La Casita
Wessex Avenue
Aldwick
Bognor Regis
West Sussex
PO21 2QW

RE: Planning Application - AW/164/21/OUT – 14 Princess Avenue – Aldwick

We write to object to this application which turns a single family dwelling into four flats for four households. The flats are to be built less than a metre from our boundary wall - at the bottom of our small garden.

Proposed Site Layout Plan at 1:100 scale

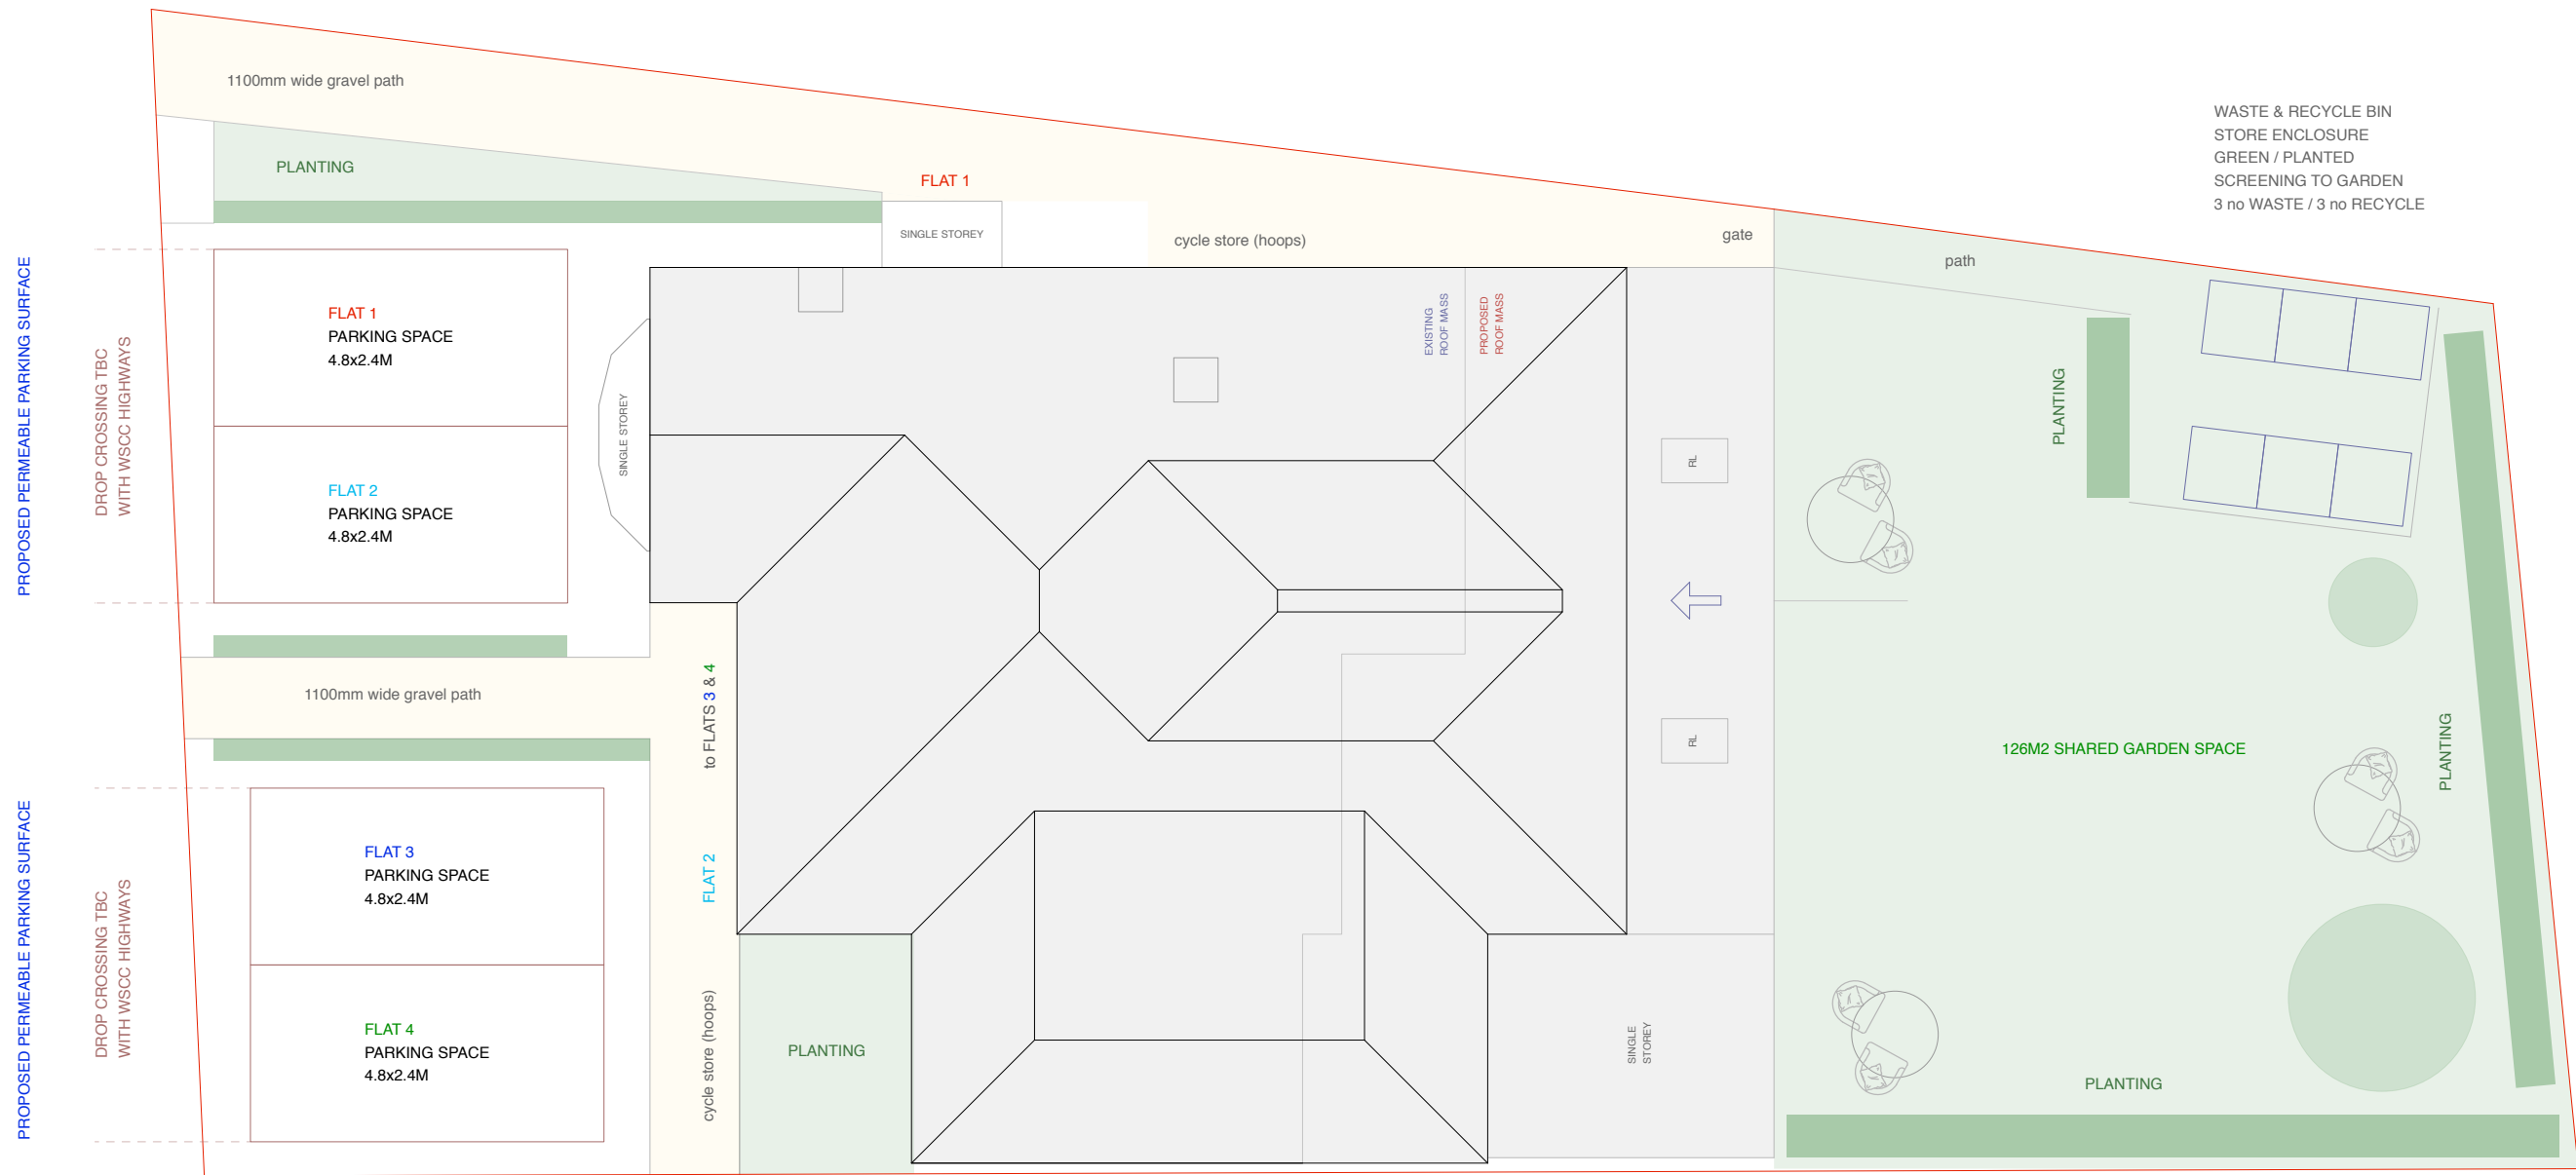
In support of their application the Applicant has submitted a Drawing No 8 - Proposed Site Layout Plan - Waste and Recycle Store - Elevations.

The applicant proposes to grub out the trees, (known habitat of small nesting birds), in the rear garden and erect waste bin stores. The stores will be open to the air in summer and winter and their rotting waste will release noxious odours into the air counter to - Policy QE SP1 of Arun Adopted Local Plan 2018 – *Quality of the environment*.

Every week the occupants of the four flats will be required to manoeuvre four black Waste Bins from the bin store in the rear garden to the road frontage of 14 Princess Avenue and back. Each single bin journey will be twenty-eight metres from bin store to road. The round trip for each bin will therefore be some fifty-six metres or 280 metres for all five bins.

There are trees in both front and rear gardens at 14 Princess Avenue. It is clear from Drawings 8 - Proposed Site Layout Plan from both front and rear gardens that all trees and grass are to be removed in order to ‘Tarmac over’ the whole of the front garden for car parking which is counter to the character and appearance of the area. In the rear garden the trees next to the north wall of the garden will need to be completely removed in order to build the Waste Bin Store and the Cycle Store as shown in Drawing No 8 – Site Plan.
